Our ref: HA/2012/112611/01-L01
Your ref: LU/5/12/
Date: 02 February 2012

ERECTION OF 1 NO. 3 BED TOWN HOUSE

**R/O 27-29B SURREY STREET LITTLEHAMPTON
WEST SUSSEX
BN17 5BD**

DRG. NO. 3243

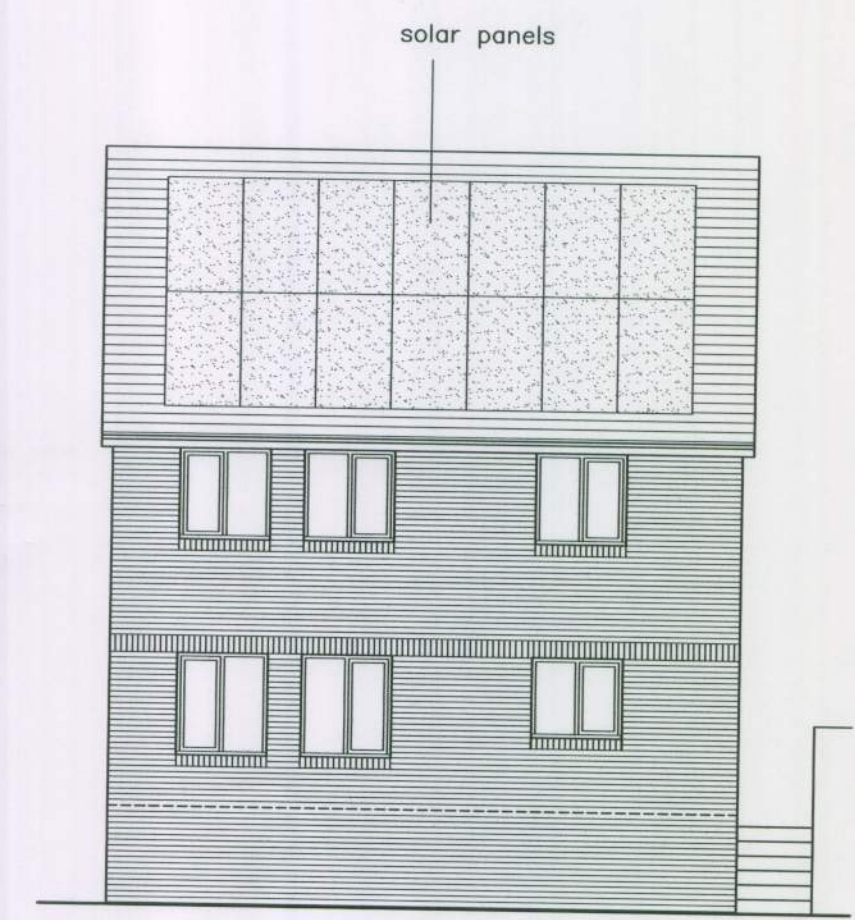
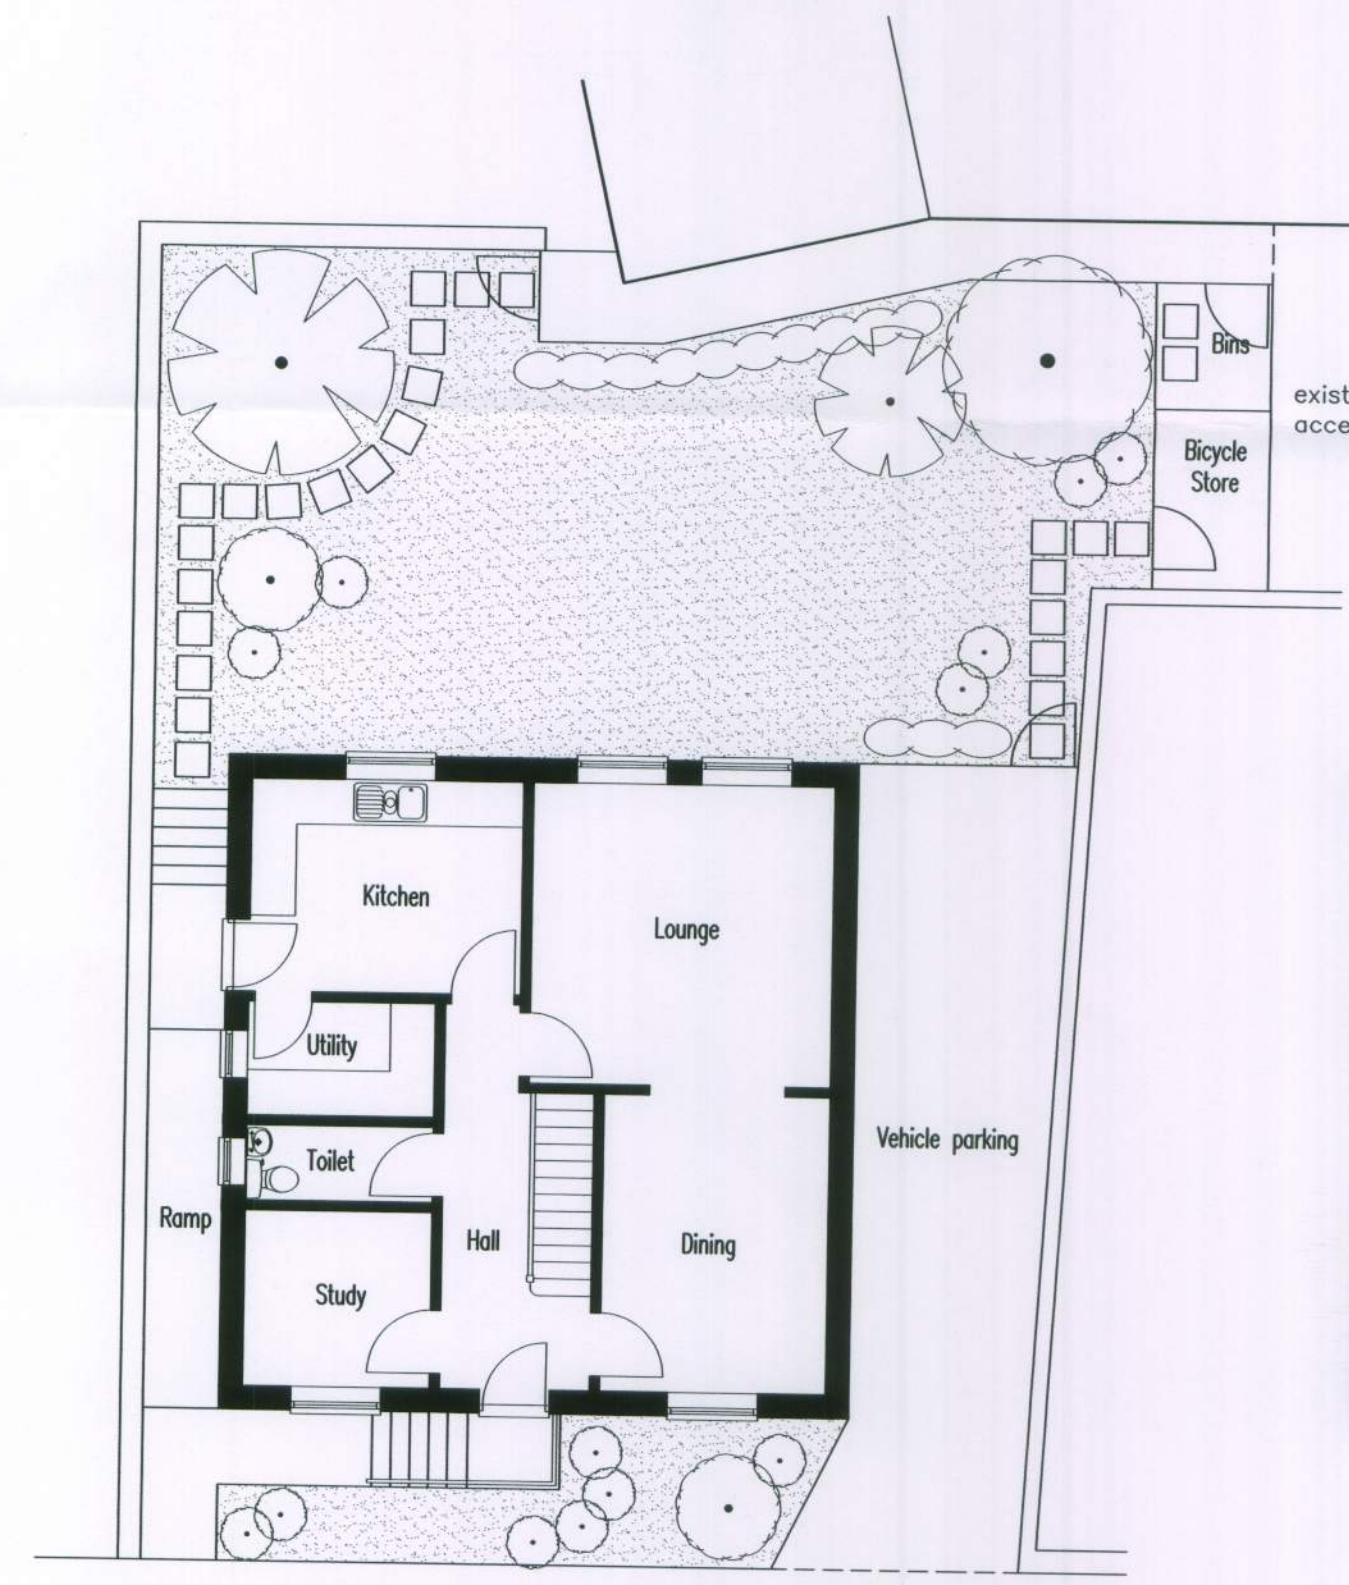
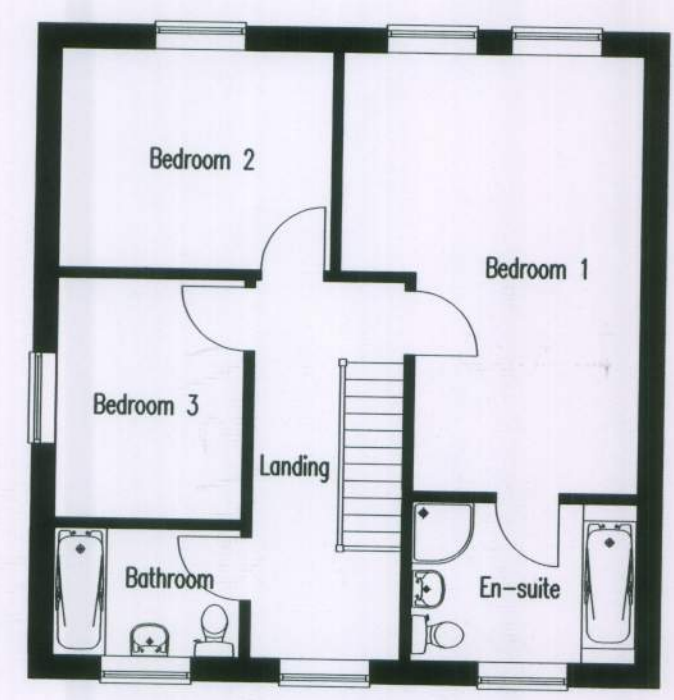
1. *Finished habitable floor levels are set no lower than 4.60 m above Ordnance Datum (AOD).*
2. *A Flood Plan should be undertaken to the satisfaction of the local authority.*
3. *Flood resilient materials be incorporated within the construction of the ground floor of the proposed development.*

The FRA submitted in support of this application shows that the building would be subject to internal, non habitable, flooding during the design event and that it is not possible for occupants of the proposed building to achieve the safe access and exit route recommended by Paragraph 8, PPS25 and Paragraph 4.60 of the PPS25 Practice Guide (December 2009).

In this instance the developer has opted for a safe refuge approach with habitable floor levels being set above the predicted flood level, excluding allowances for climate change. Reference is not made to the need for a Flood Plan within the FRA, however, we would recommend that one is undertaken to your authorities satisfaction or that the existing Flood Plan be amended to include this development.

The application site lies within Flood Zone 3 defined by PPS25 as having a high probability of flooding when including allowances for climate change over the lifetime of the development, and R&D report FD2320/TR2, Flood Risk Assessment Guidance for New Development, states that this represents a 'danger for most', although the duration of flooding will be limited to a couple of hours either side of the extreme tide peak. The anticipated maximum flood depth on the site is 1.70m during the 2115 flood event, which would result in an internal depth of approximately 0.5m.
